From: Paul Cann
Sent: 05 October 2017 16:11
To: Planning.Responses
Subject: RE: Planning Consultation on: A/169/17/OUT

Engineers comments in respect to surface water drainage:

APPLICATION A/169/17/OUT

Site Address: Land west of Brook Lane & South of A259 Angmering

MASTER PLAN

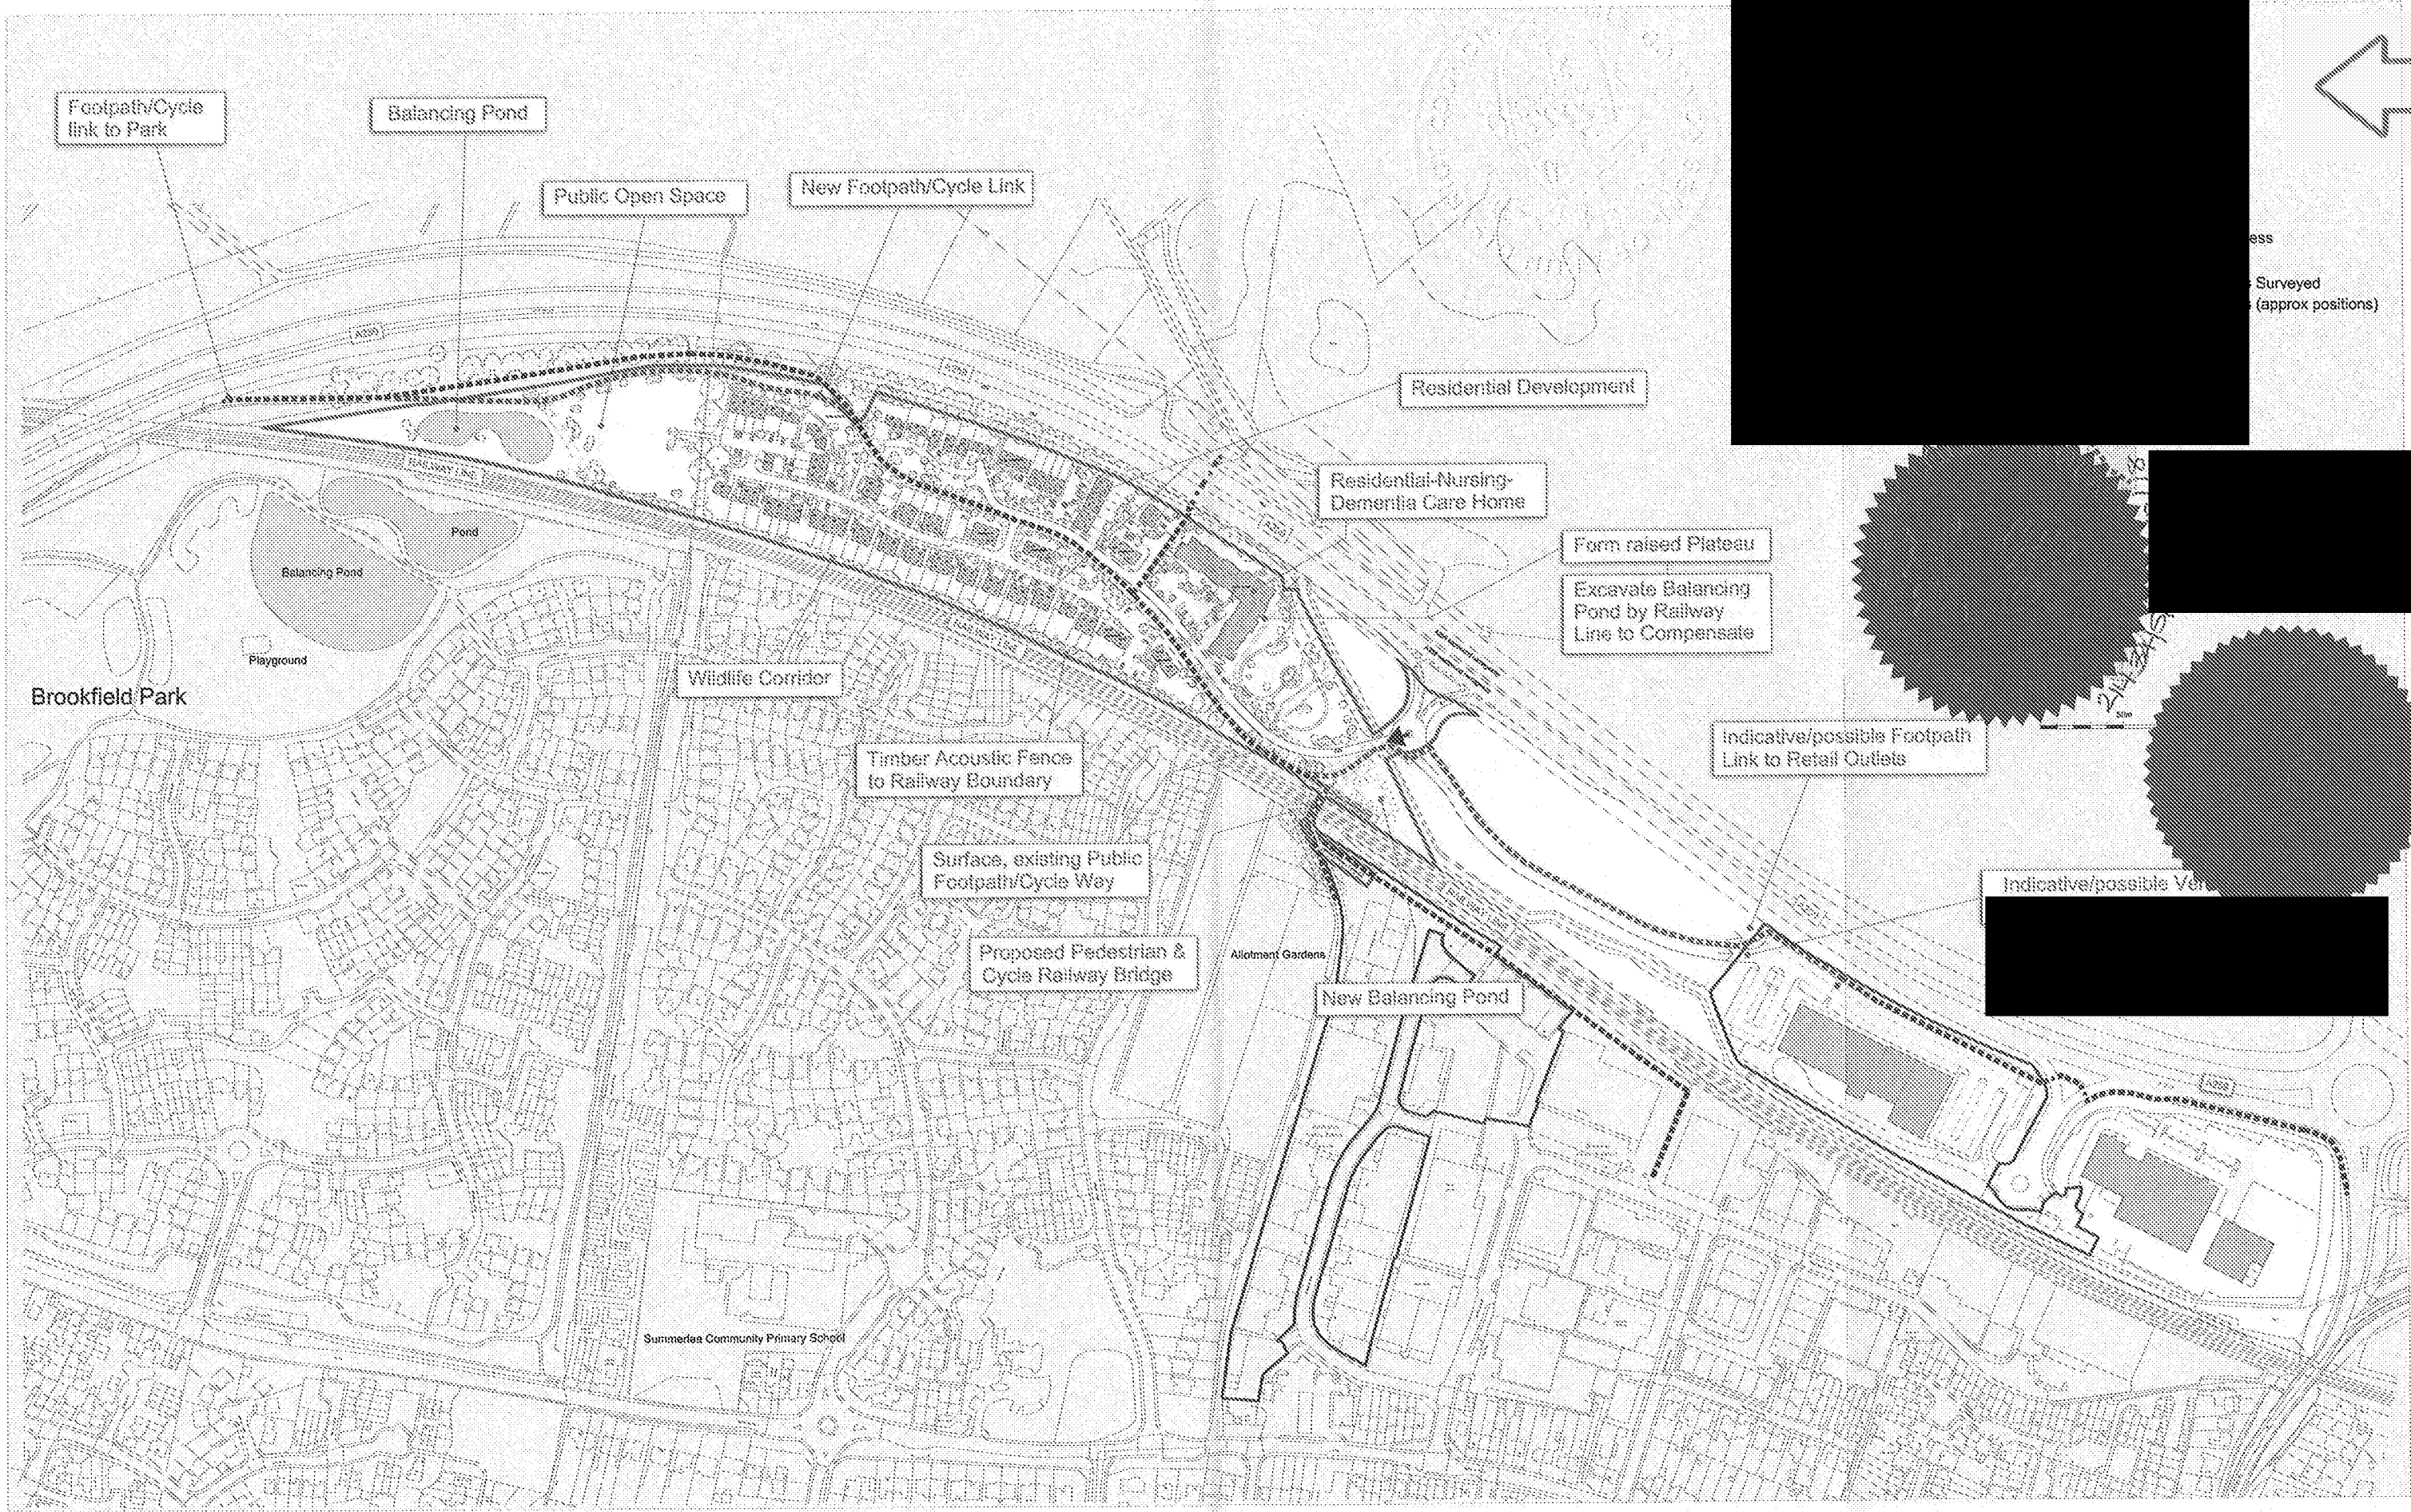
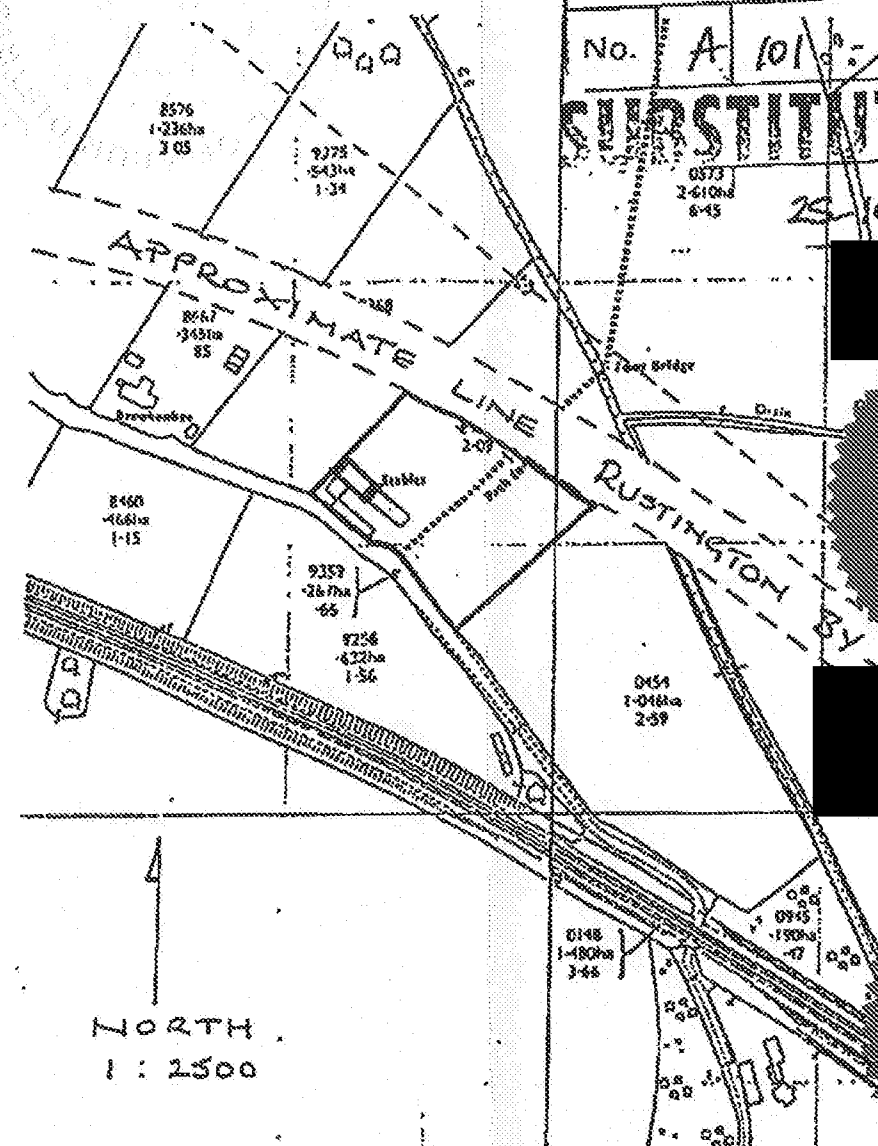
A number of ordinary watercourses pass through the site, including the 'main river'. Land drainage consent will be required for any culverting or alteration to these watercourses. It is likely that improvements will be required to these assets. The Environment Agency should be consulted in respect to the 'main river'.

The proposed balancing pond location is occupying land that floods and also the overland flow route that transfers surface water/land drainage flows from developments/land south of the railway line via the railway culvert, then across the land in question and into the culvert beneath the A259. The applicant is urged to discuss this matter further with ourselves.
